**Hunter Valley Operations South - Modification 5 (MP 06\_0261) – Response to Submissions**

I refer to your email of 15 June 2017 inviting comment on the Response to Submissions (RTS) exhibited on the NSW Department of Planning & Infrastructure web site in relation to the Hunter Valley Operations South - Modification 5 (MP 06\_0261) (the Project).

Figure 1: Predicted annual average $PM_{2.5}$ concentrations due to emissions from the proposed modification and other sources in Stage 2 ($\mu g/m^3$)

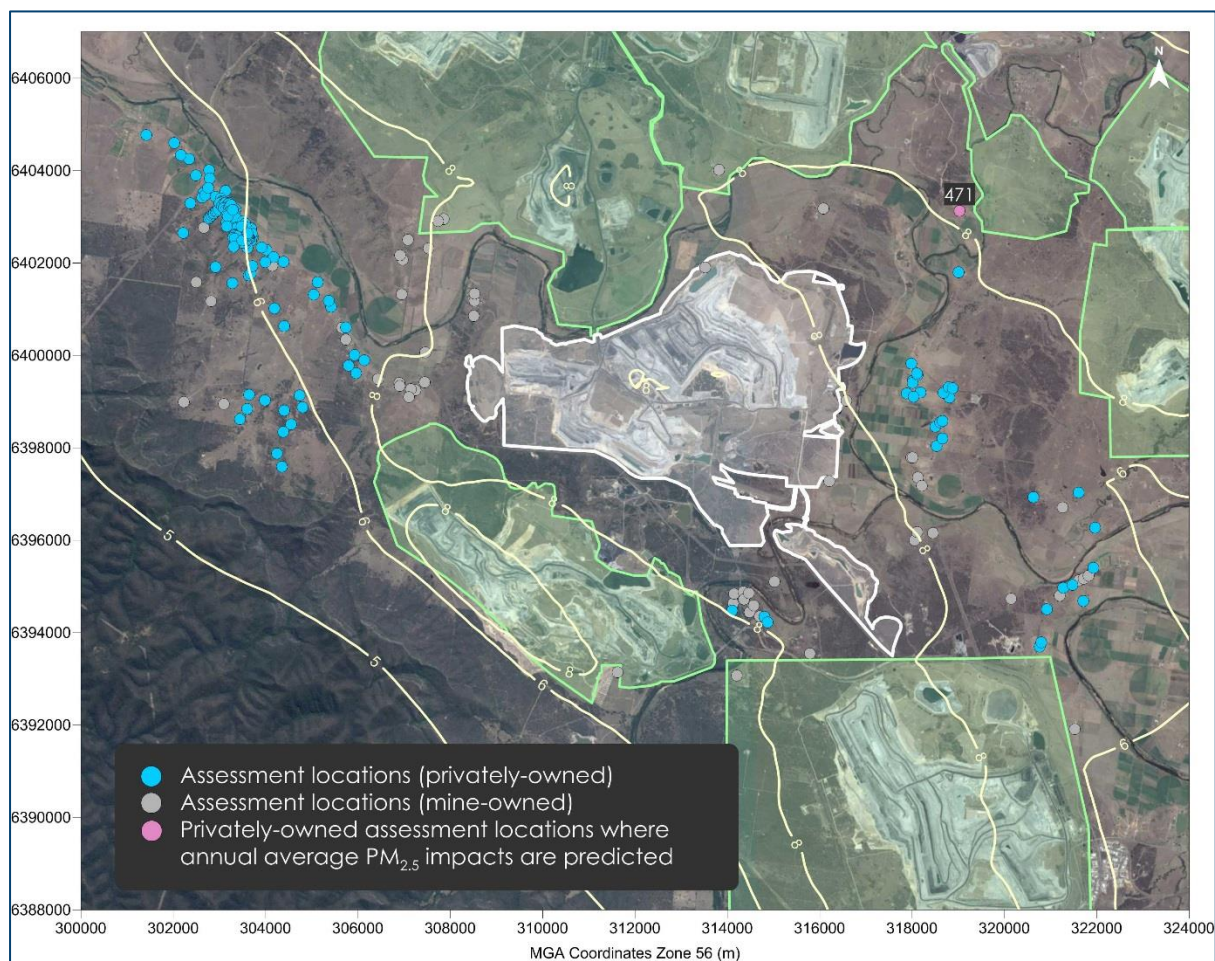
We requested the proponents provide an isopleth for a  $PM_{2.5}$  level of  $7\mu g/m^3$  to Figures 1 (Stage 2) and 2 (Stage 3) to incorporate the variation to the National Environmental Protection (Ambient Air Quality) Measure (NEPM) air standard for annual average  $PM_{2.5}$  air standard of  $7\mu g/m^3$  which will be in force by 2025. Figures 5.18 and 5.19 on pages 101-102 of *Hunter Valley Operations South - Modification 5 -Response to Submissions – June 2017*, now show that there are several residences that will be subject to  $> 7\mu g/m^3$   $PM_{2.5}$  during Stages 2 and 3 of the Project. There are also multiple residences where the NEPM air standard for  $PM_{10}$  will not be met.
